A47 DUALLING – NORTH TUDDENHAM TO EASTON

Scheme no. TR010038

COMMENTS BY A C MEYNELL of the [REDACTED]
[REDACTED] on APPLICANT'S DEADLINE 7
SUBMISSIONS AND HISTORIC ENGLAND'S DEADLINE
6 SUBMISSION
IP reference 2002/8353

25 January 2022

# PROPOSED WOOD LANE JUNCTION

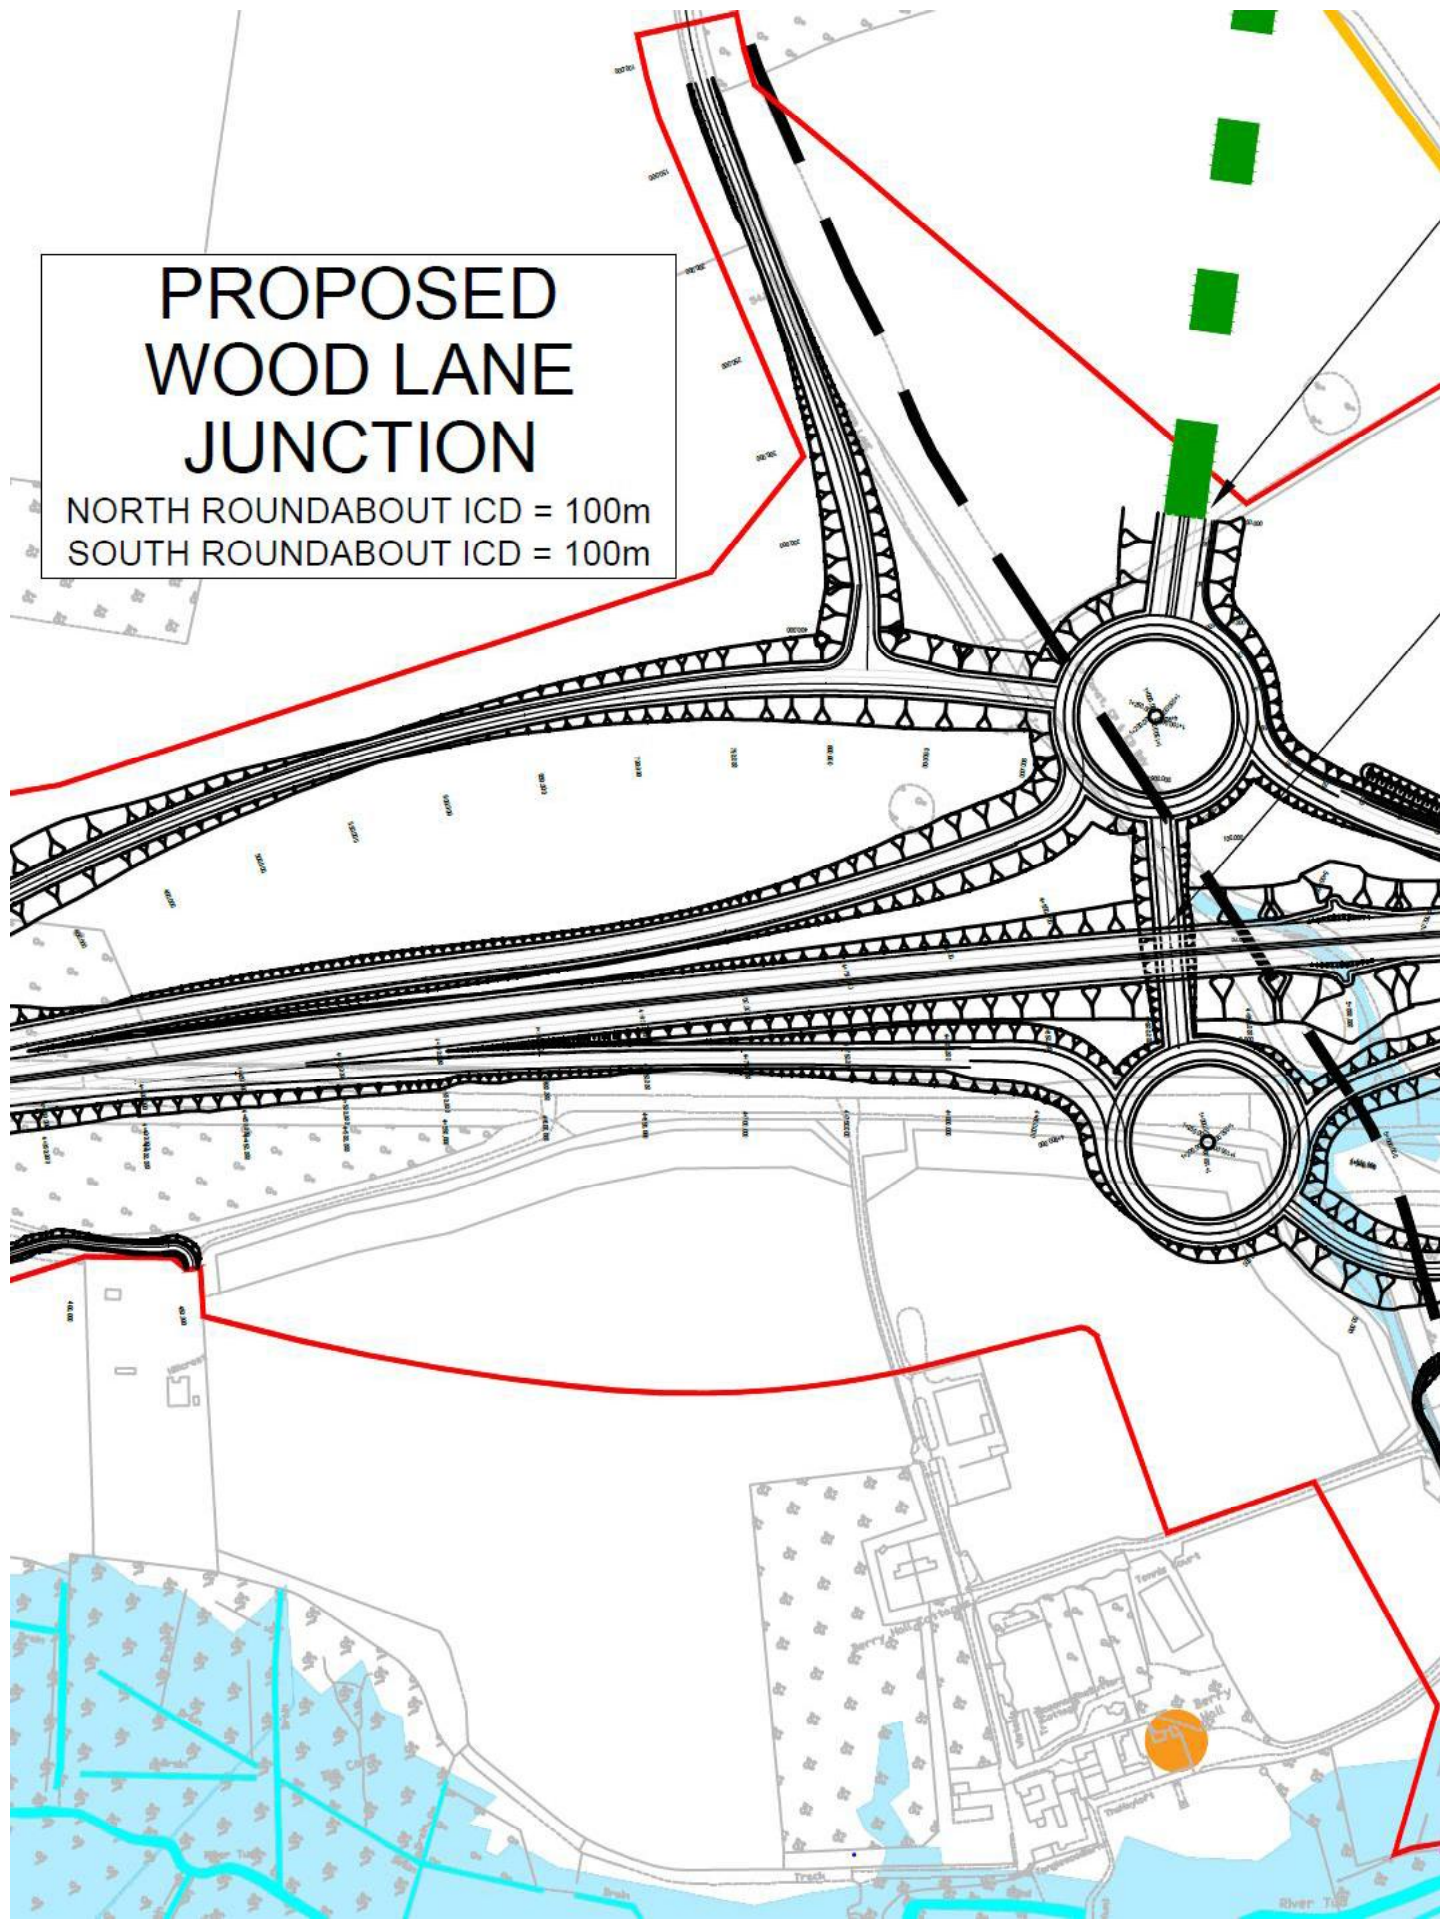
ACM notes that if the Inscribed Circle Diameter (ICD) of the south dumbbell were to be reduced to 70m, the roundabout as well as being retained within the northern woodland belt of the Estate (see REP7-037, App C, photo 6), would have its south-western segment at current ground level or thereabouts and not need an embankment at sections E and F. Will the Applicant confirm?

Figure 6.1 – Proposed Temporary Construction Compounds

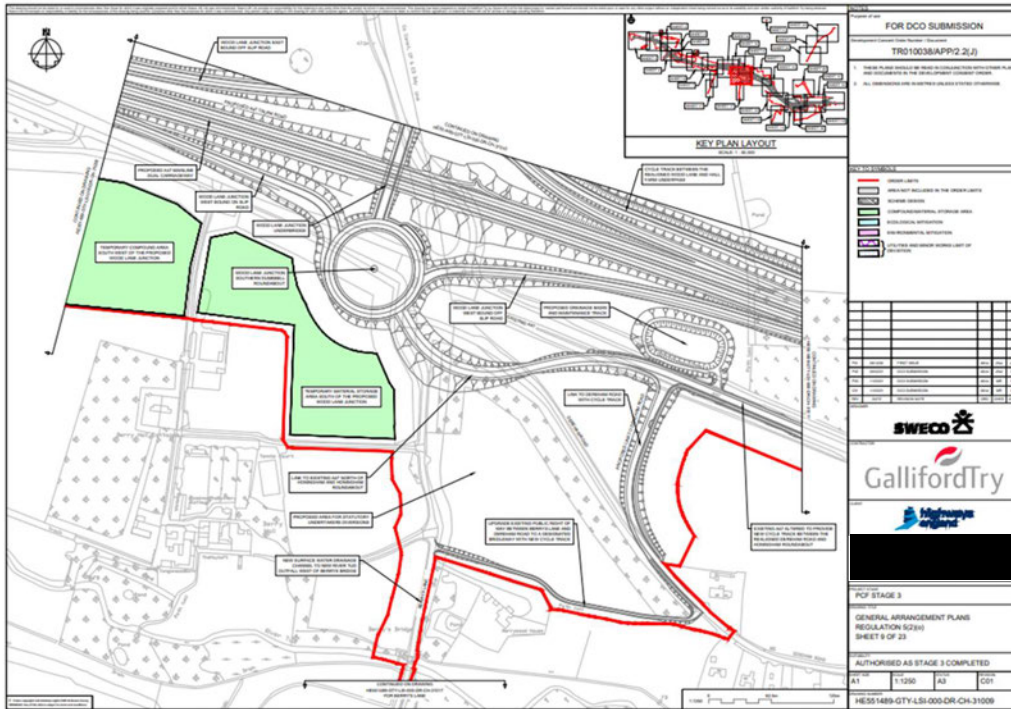
- b. *Effects on Commercial receptors.* The Applicant's comment is noted, but although it may not have been clear the reasons for mentioning them where Mr Thomas did (at REP6-033, para 4.1) was in the context of their importance to the preservation and maintenance of the Estate as a heritage asset. This importance is described in ACM's statement (REP1-045) at paras 111 to 117 (pages 39-41).
- c. *Countryside Stewardship Status.* As mentioned at ISH3, the CSS scheme on the Estate has been renewed for 5 years from the expiry of the former scheme in December 2021. ACM can give evidence of this if requested. ACM welcomes the recent exclusion of the CSS field margins from the proposed temporary compounds so they can be maintained, as evidenced by the proposed compounds plan now produced at REP7-017 (pdf page 74/74)

<i>Item</i>	<i>Pdf page</i>	<i>REP7-036 Topic / matter covered</i>	<i>ACM comment</i>
			Woodland Belts G232 and G159 and the field margins and fields beside them to them lying within the Estate adjacent to and outside of the Wood Lane junction south dumbbell and its approach roads, or to be retained or replaced within the roundabout, Highways England shall have due regard to and, acting reasonably, agree to the implementation of a programme of retention or replacement of existing trees to be selected and provided by the owner of the Berry Hall Estate for consistency with those currently planted in the two woodland belts referred to.”
BD1	30/74	To avoid disturbance on wintering and feeding birds	For the protection of the winter bird feeding and nectar areas on the Berry Hall Estate, add at end “ In relation to Satellite Compound 2 and the adjacent soil storage area (Wood Lane Junction) the Applicant shall consult and, both parties acting reasonably, agree with the Berry Hall Estate owner the timing of vegetation clearing works in summer following harvest, and lighting systems in accordance with this section, and will similarly consult and agree with any reasonable requirements of the Estate owner over the timing to be in summer for remediation and the timing, species and methodology for planting (and whether or not bird boxes will be required). Noise protection bunds will be constructed and CSS filed margins, woodland and hedgerows shall all be protected outside the compounds as shown on Plan [xxx] [at final page of REP7-017]
